DRB Project Number: 2021-005508 Hearing Date: 06-25-2025
Project: 9311 Coors NW Agenda Item No: 5

Request: Create five new tracts from one existing tract and grant additional water and sewer easement with this minor subdivision plat.

Application For: MINOR PLT-2025-00013 – PRELIMINARY/FINAL PLAT

Drawing file: PR-2024-005508_PS-2024-00042_March_6_2024 (Sketch) / 240156_Plat_3-5-24.pdf

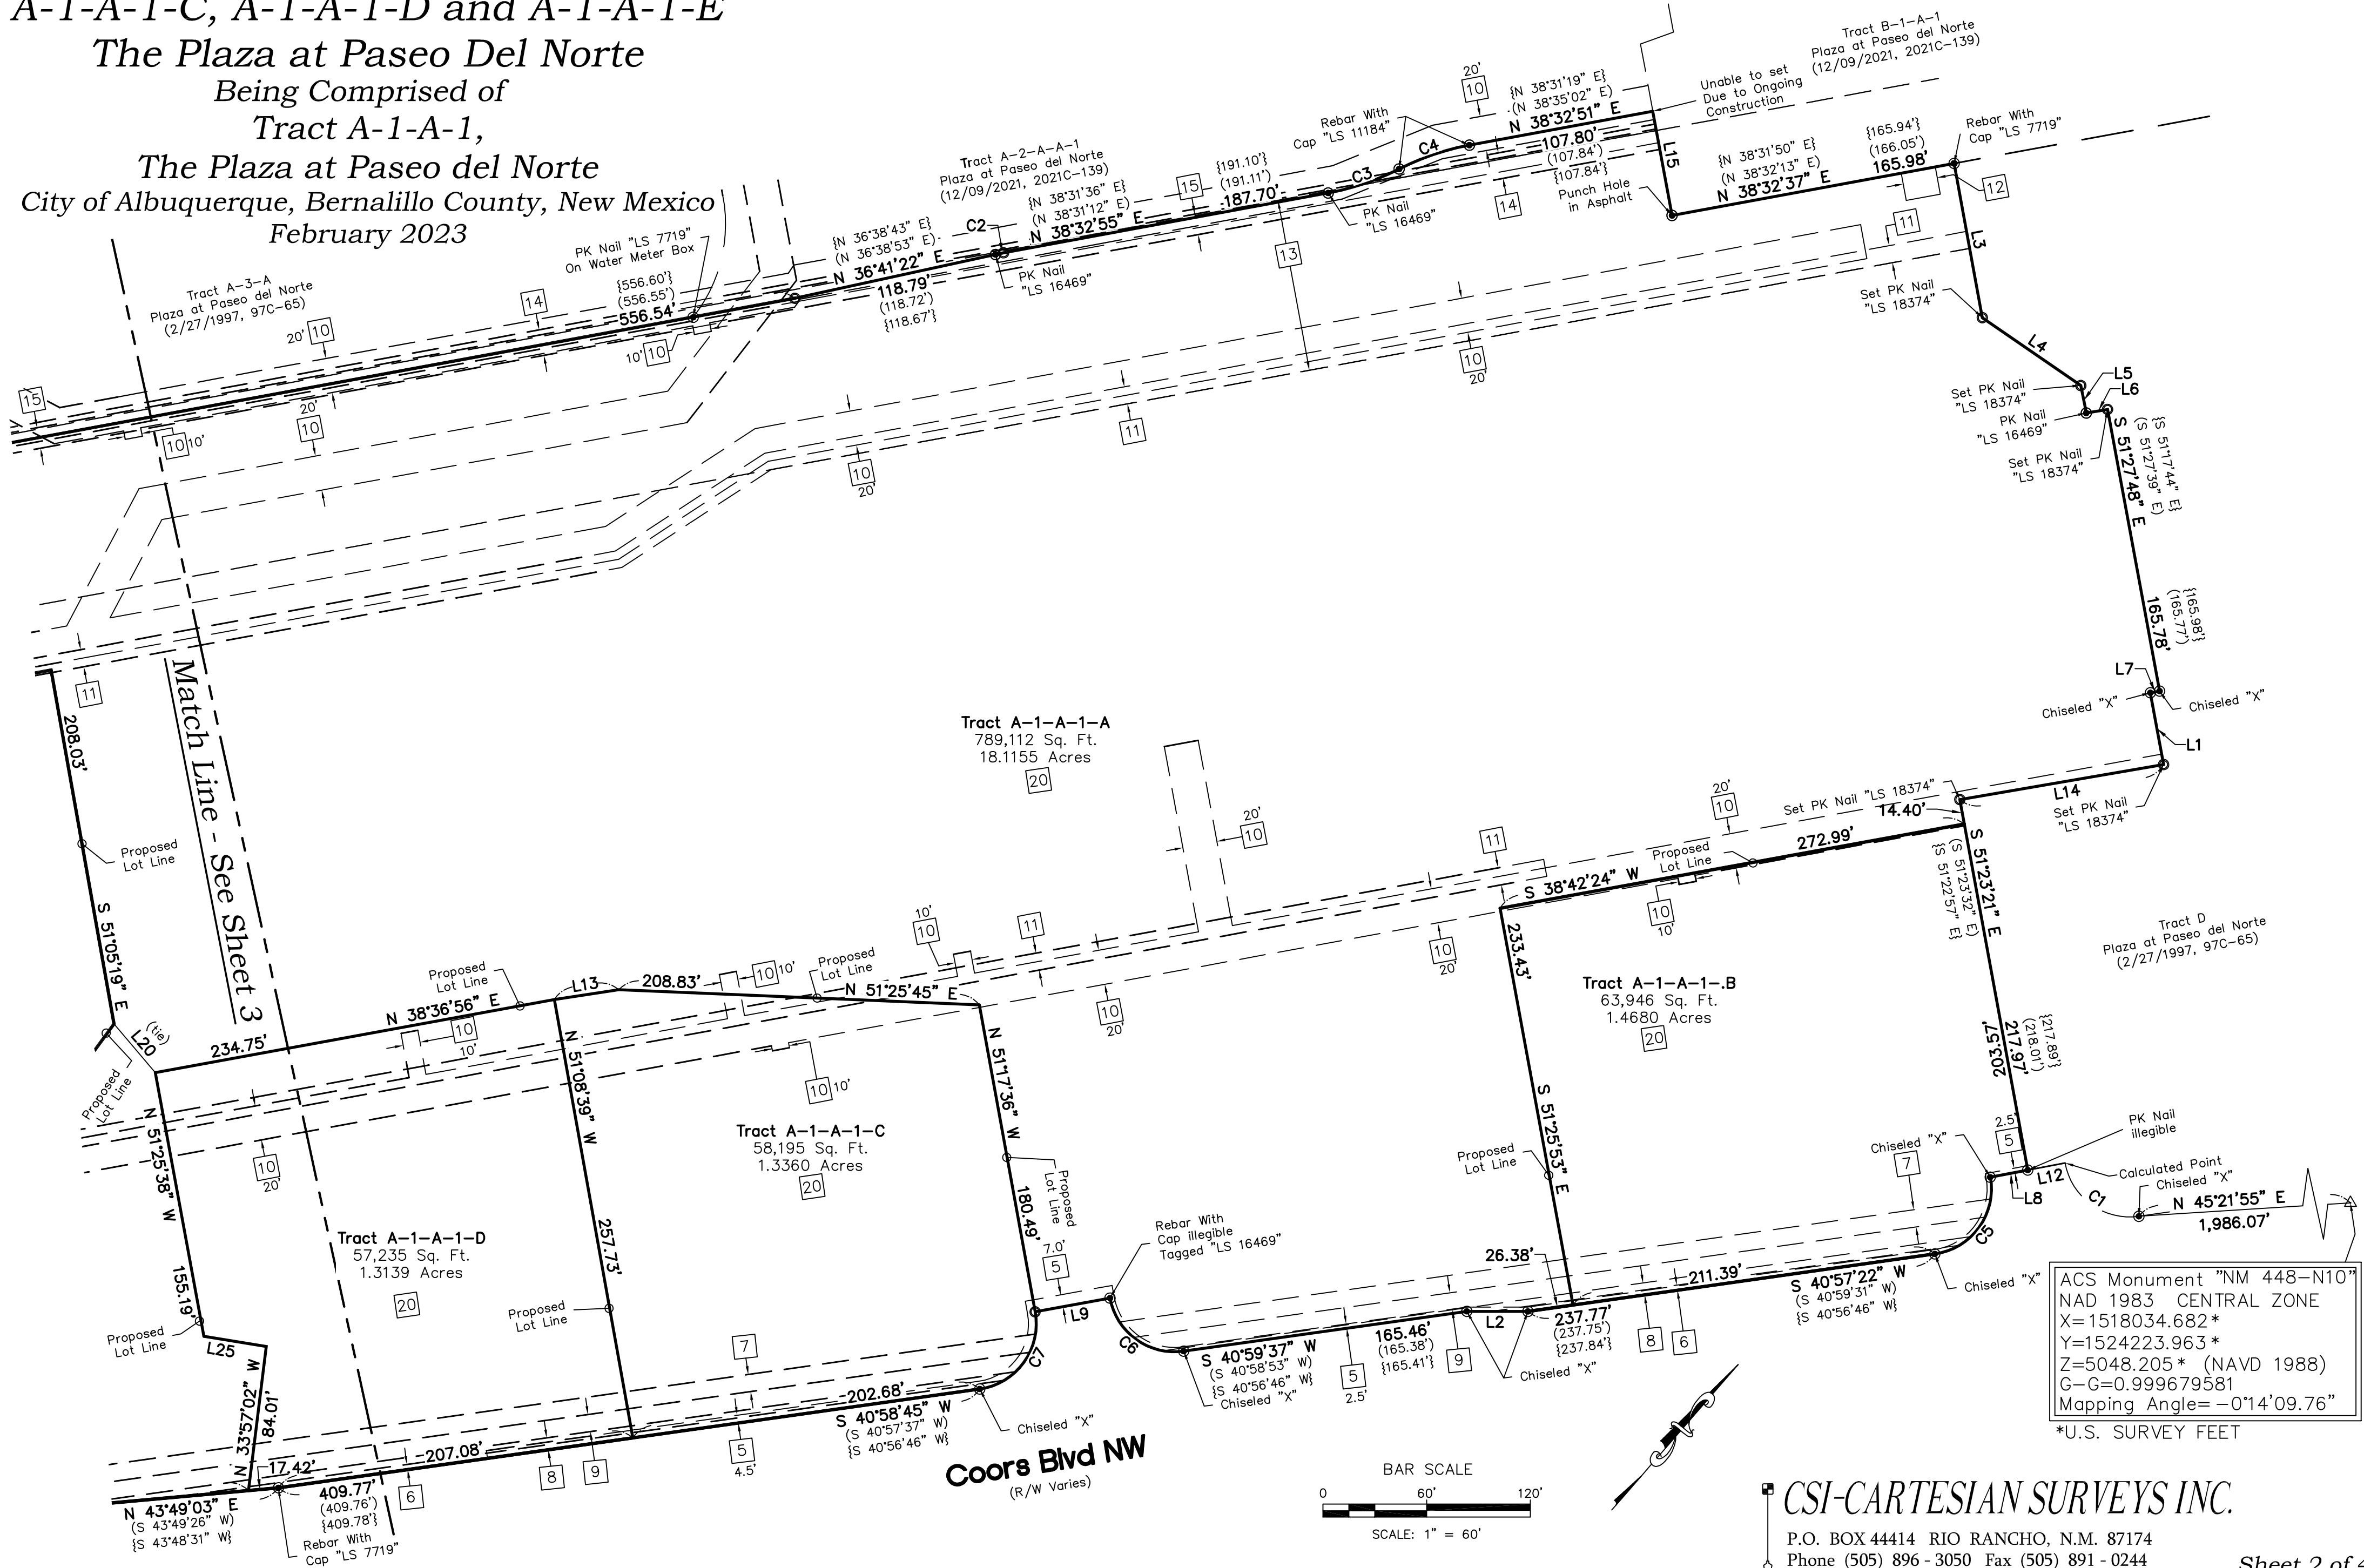
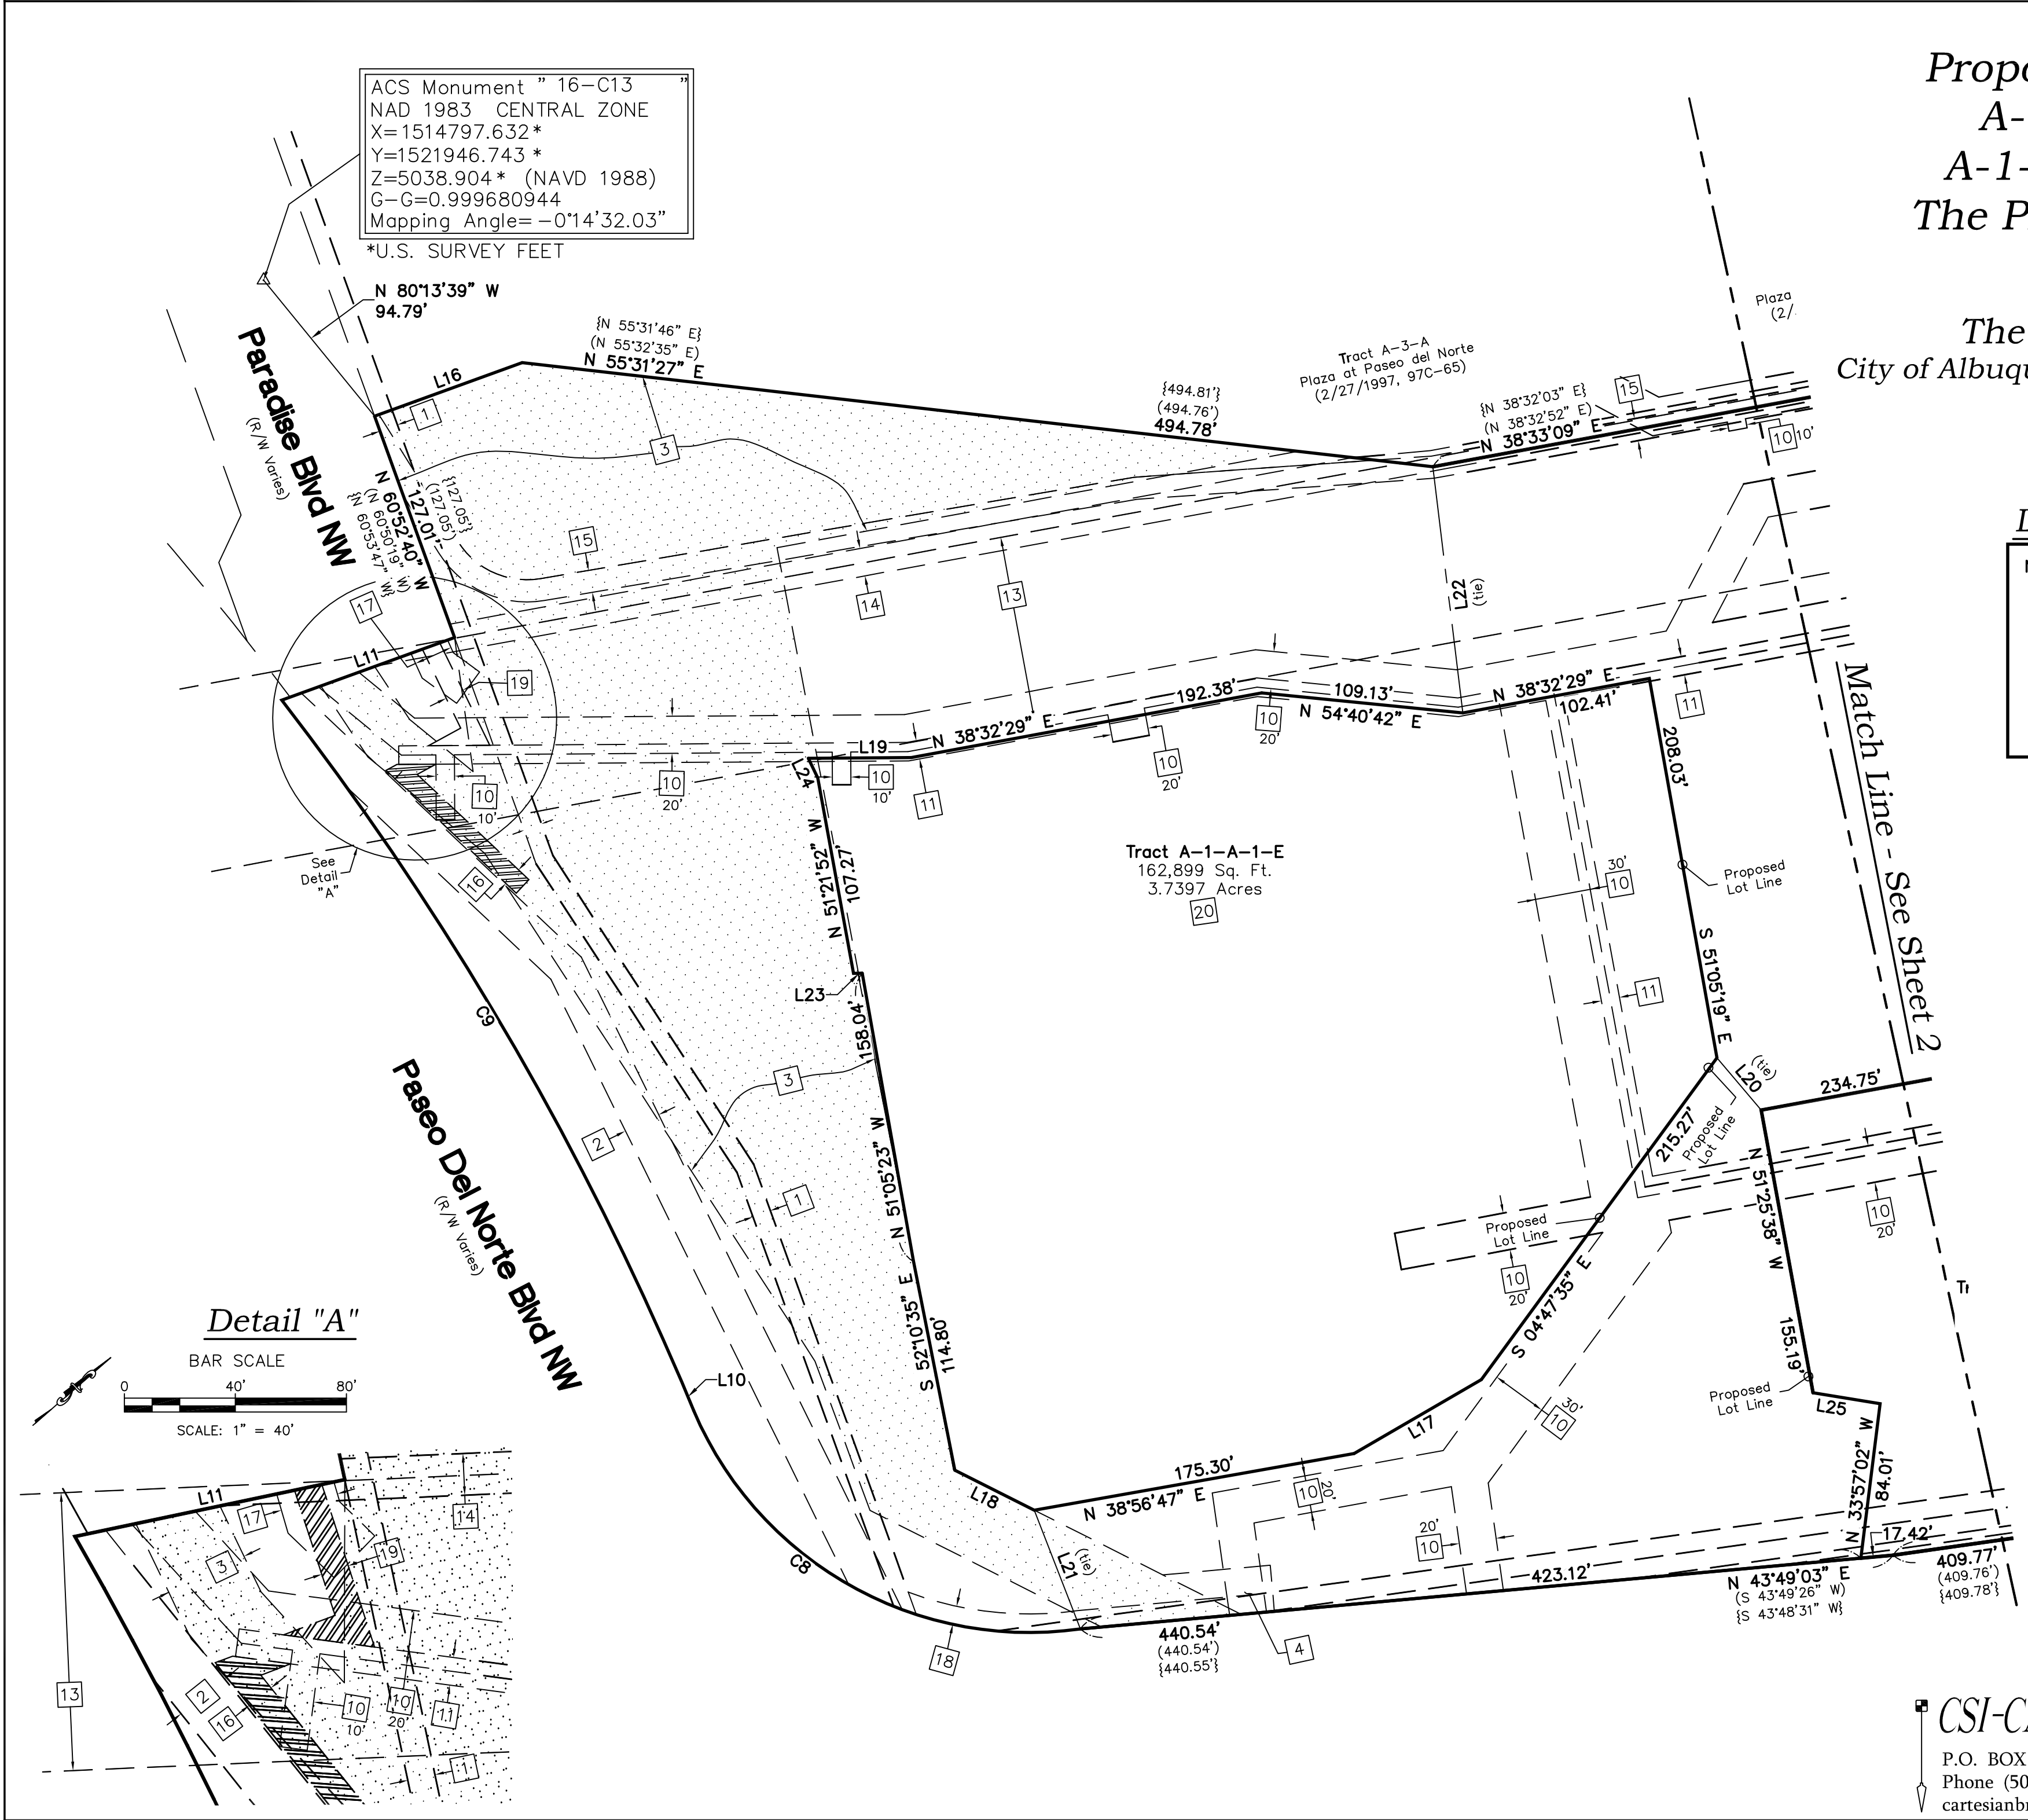
1. Previous Sketch Plat comment: (Did not see a revised plat)
 - a. Easement #7 is shown as 10' wide. Please provide an additional 10' to provide an adequate corridor for the existing 12-inch sanitary sewer collector line.
